Online Comment

Application H13-0507-24
Location Rear of War Memorial Seas End Road Moulton Seas End PE12 6LD
Proposal Residential Development - 2 Dwellings - Outline Approval H13-0651-20

Name Greg Watkinson
Address Conservation Officer

Date Submitted 31-07-24
For/Against Comments

J185-PL 12

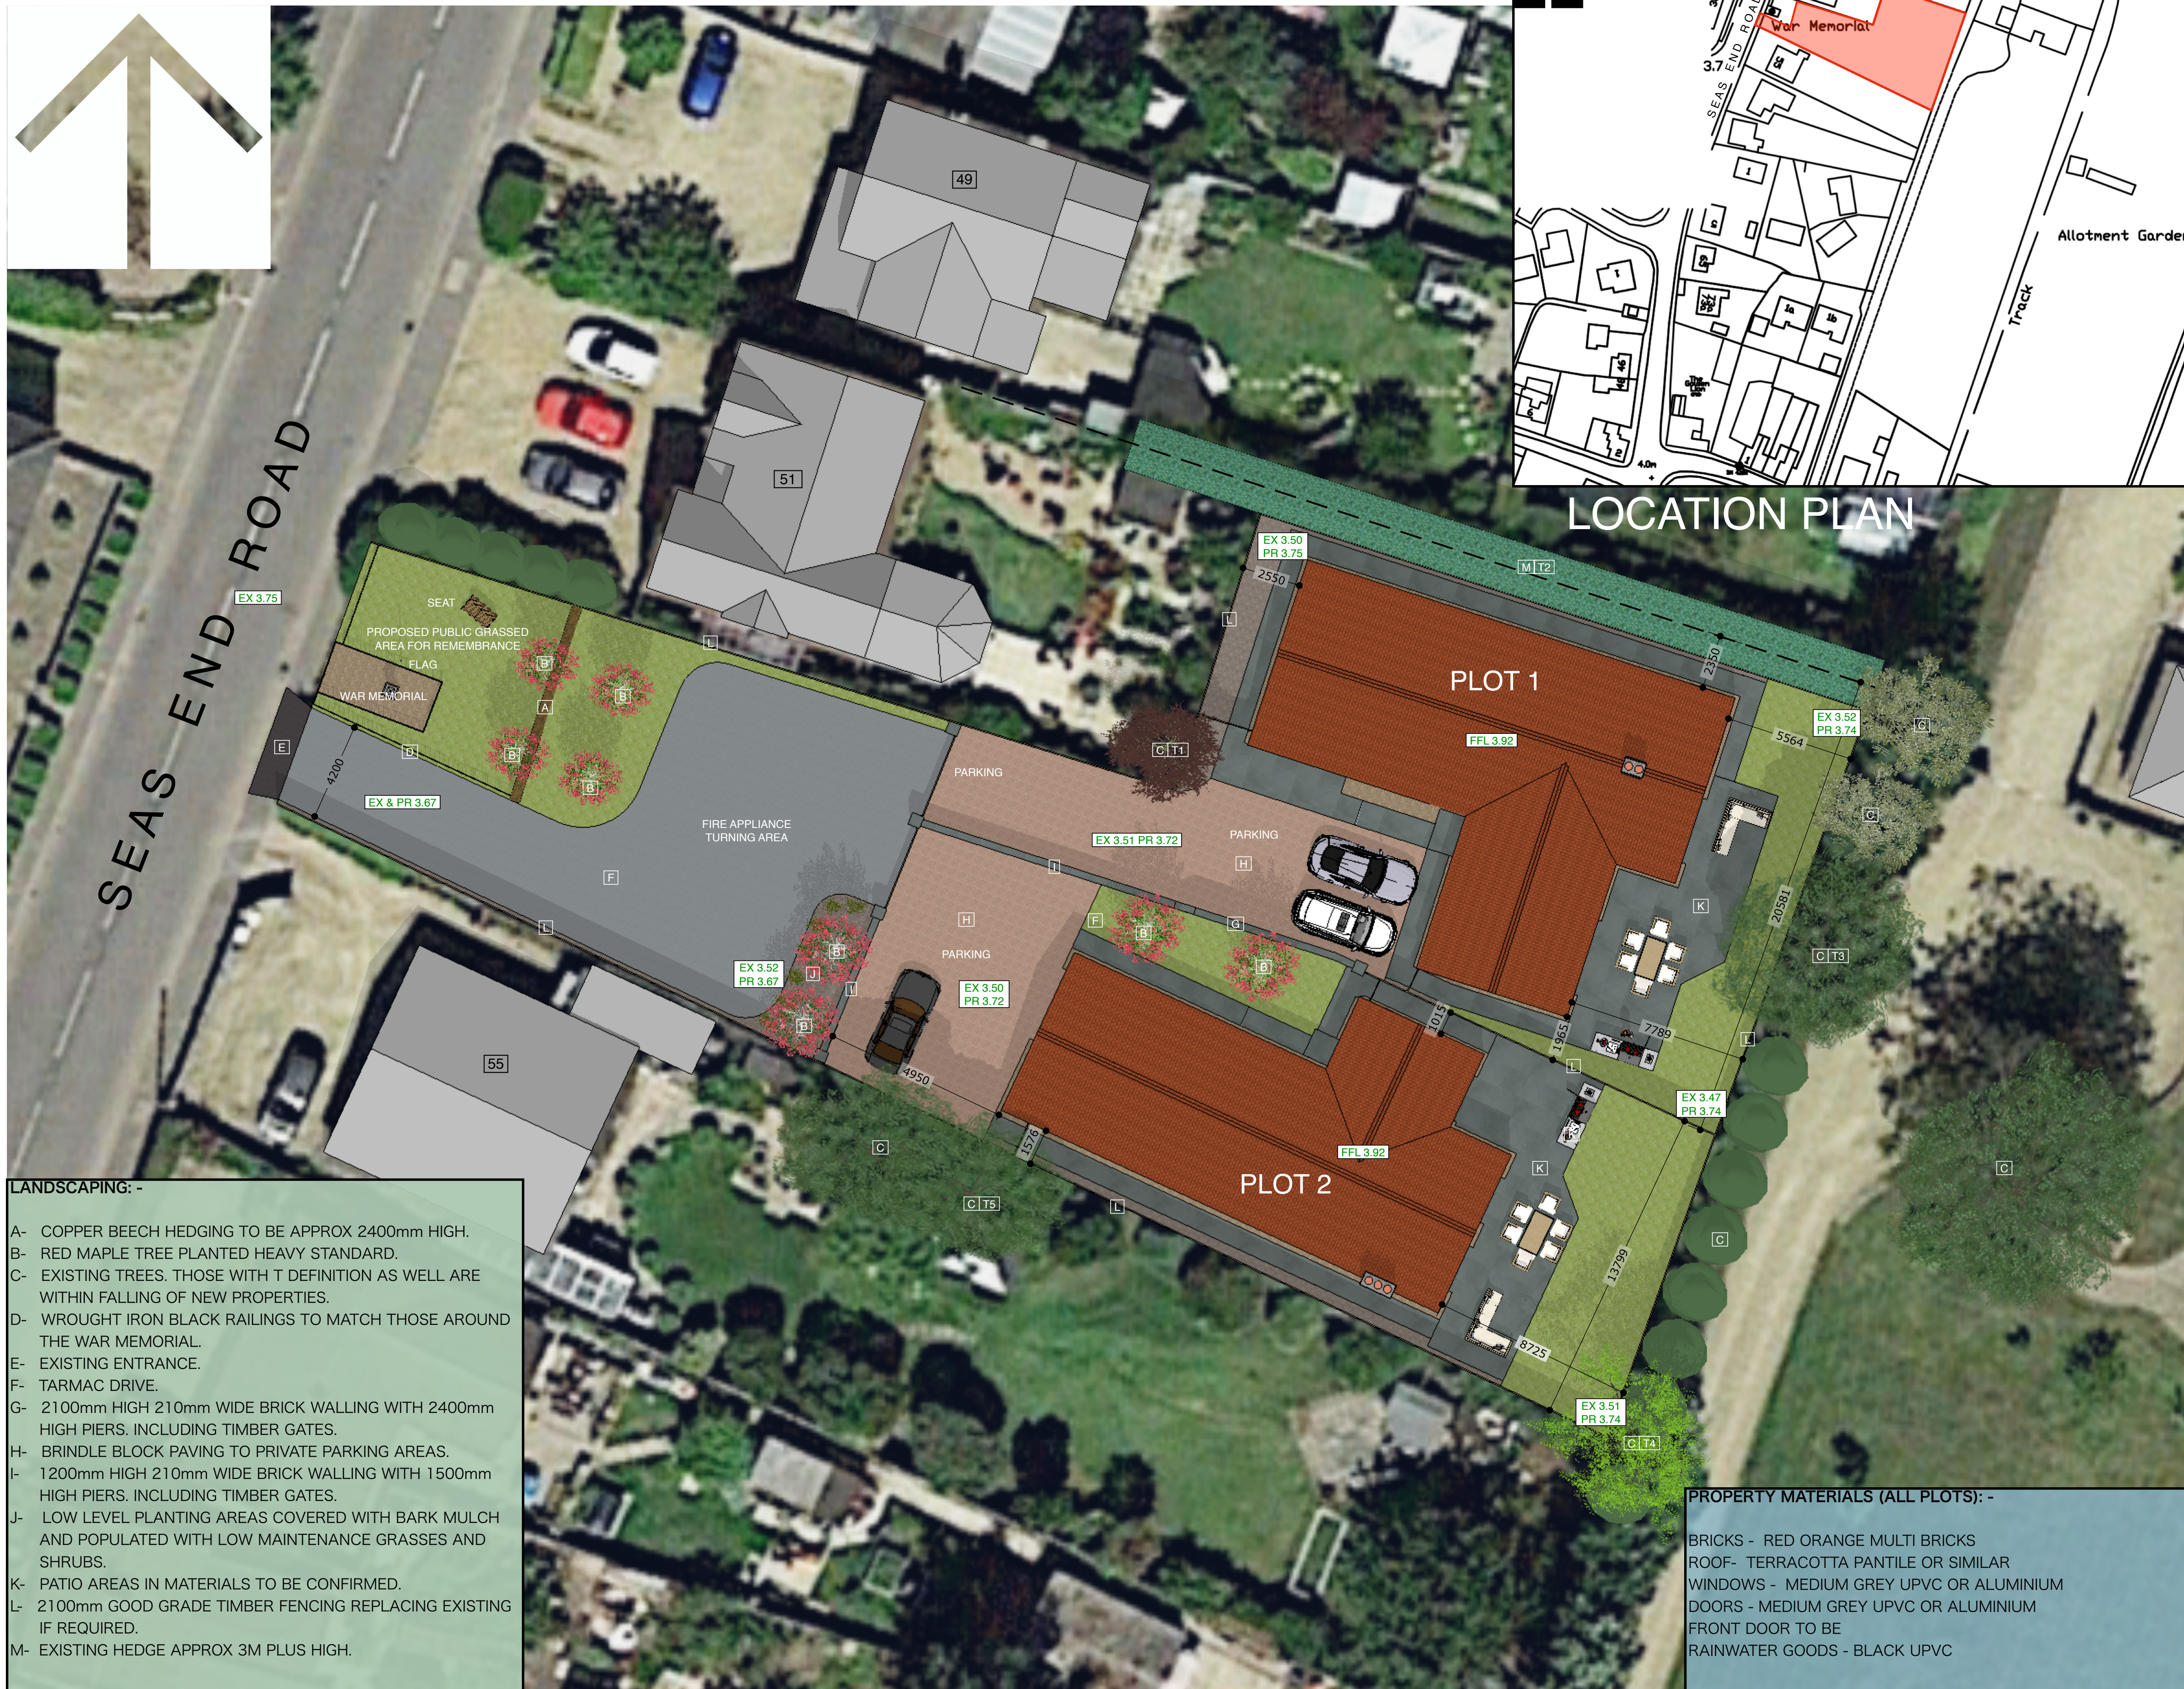
Given the sensitive setting, it is appreciated that single storey dwellings have been proposed that are set as far back within the plot and away from the war memorial as possible, retaining a modest area of open space around the heritage asset to allow for ceremonial gatherings and quiet contemplation. Due to this, the proposed planting and the single storey nature of the proposal, I would suggest that the impact upon the setting of the listed memorial is such that it presents no substantive harm to the significance of the asset.

I would, however, suggest conditions to affirm the details of the final external materials, and also to ensure that the scheme of planting is both implemented and thereafter so maintained.
